SSD 6011 - Mixed use residential development within the South West Plot

Submission by:

Qing Crugnale and Peter Crugnale

30 July 2013

DEVELOPMENT APPLICATION
SOUTH WEST PLOT
WEST ELEVATION

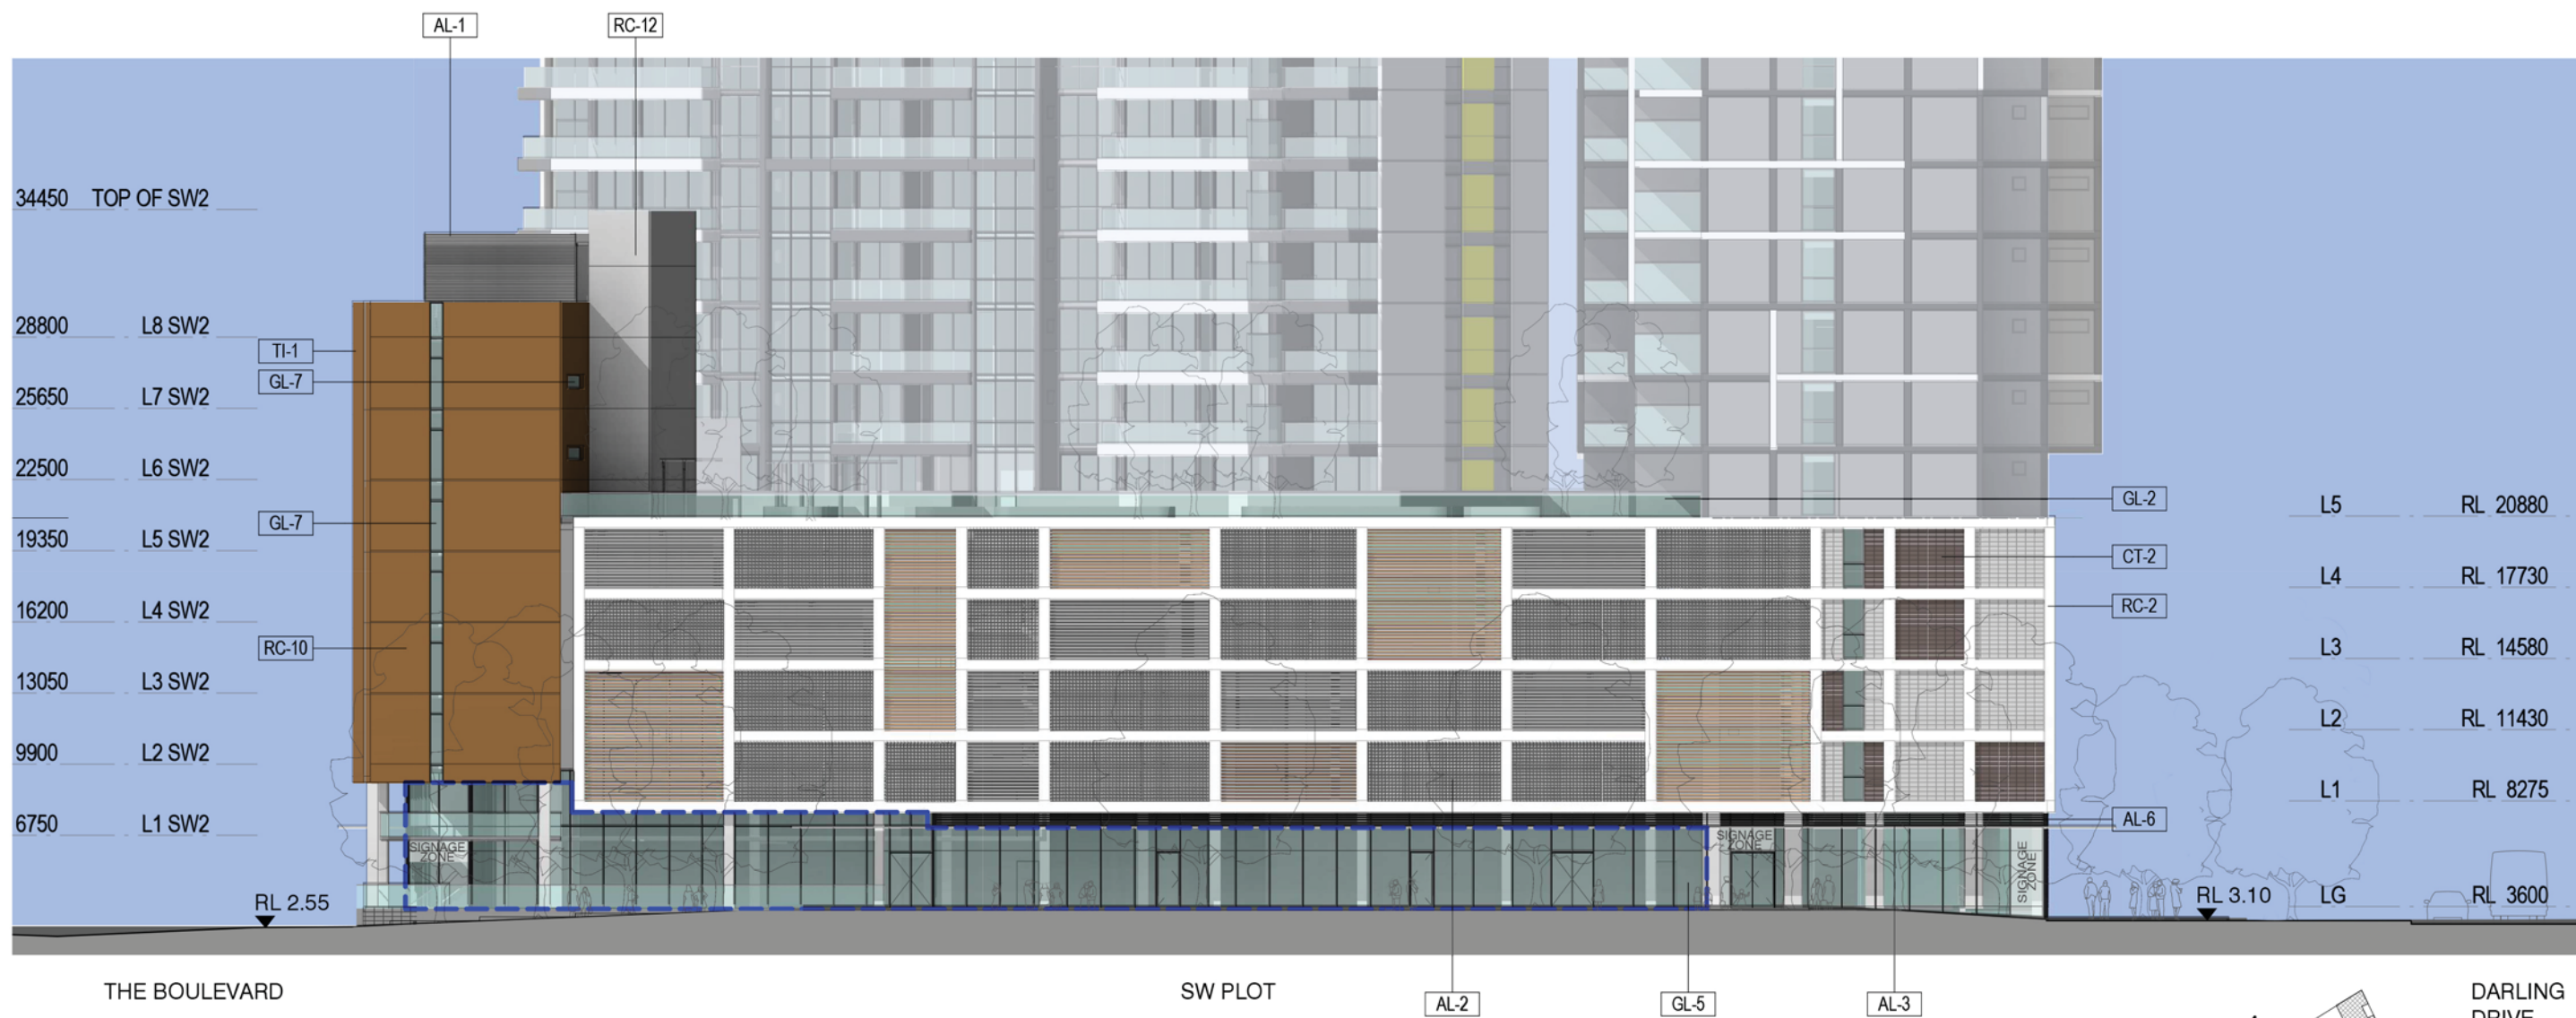
The proponent fails to take into account the existing shadowing of the west façade of The Peak.

At 9am, 10am and 11am the west façade is totally in shadow due to other parts of The Peak building itself.

At 12pm there is still substantial existing shadowing on the west façade caused by the irregular shape of the west facade.

At 1pm the existing shadowing has been substantially removed, but not totally removed.

It can be concluded that some single aspect apartments on the west façade and some south-west dual aspect corner apartments currently receive less than 2 hours direct sunlight to habitable rooms and 50% of the private open space between 9am and 3pm on 21 June.

At 9am, 10am and 11am the west façade is totally in shadow due to other parts of The Peak building itself.

At 12pm there is still substantial existing shadowing on the west façade caused by the irregular shape of the west facade.

At 1pm the existing shadowing has been substantially, although not entirely, removed. However, overshadowing of lower levels of the west façade by the concept proposal parameter plan shadows for the N,NE and SE plots has already started.

By 2pm the existing shadowing has been totally removed. However, overshadowing of the west façade by the SSDA4 and SSDA5 buildings has appeared and risen further up the west façade than the concept proposal parameter plan shadows for the N,NE and SE plots, which is still present.

At 3pm, the proponent states correctly that 45-45% of the western façade is overshadowed by the SSDA4 and SSDA5 buildings.

It can be concluded that, as a result of combination of the proposed development with existing shadowing of the west façade, some single aspect apartments on the west façade and the south-west dual aspect corner apartments which currently receive less than 2 hours direct sunlight to habitable rooms and 50% of the private open space between 9am and 3pm on 21 June will suffer additional overshadowing. It is beyond our skills to count the number of such apartments. We note that the proponent has made no attempt to do so.
